October 21, 2013
File: 13105

RE: 133 YORK STREET

Attached are revised plans for the project. The changes include:

3 DRIVEWAY APRON LAYOUT (I-9)

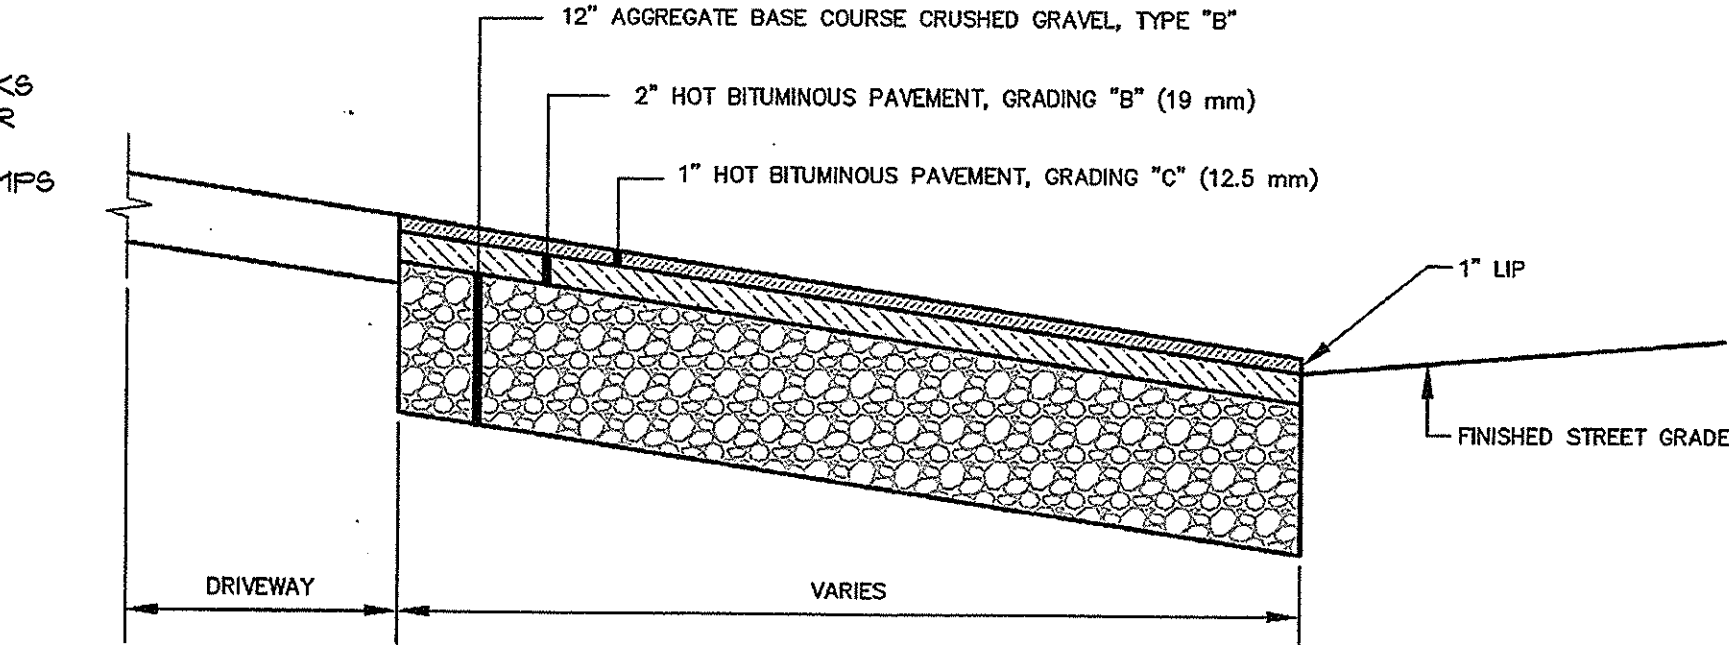
1. Revised driveway entrance to remove brick sidewalk and cobblestones.
2. Revised electrical and gas service to come from York Street.
3. Revised landscape plan per Jeff Tarling's email.
4. Have labeled 20' fire land and no parking.
5. Provide revised drainage calculation and maintenance requirements for the stormwater system.
6. We have provided a narrative on the construction plan.
7. Attached are revised parking templates. As you can see we can get very large vehicles, 19' in length, into and out of the spaces. We expect much smaller vehicles will use the spaces.
8. We have revised the survey to add the coordinates to the plan.
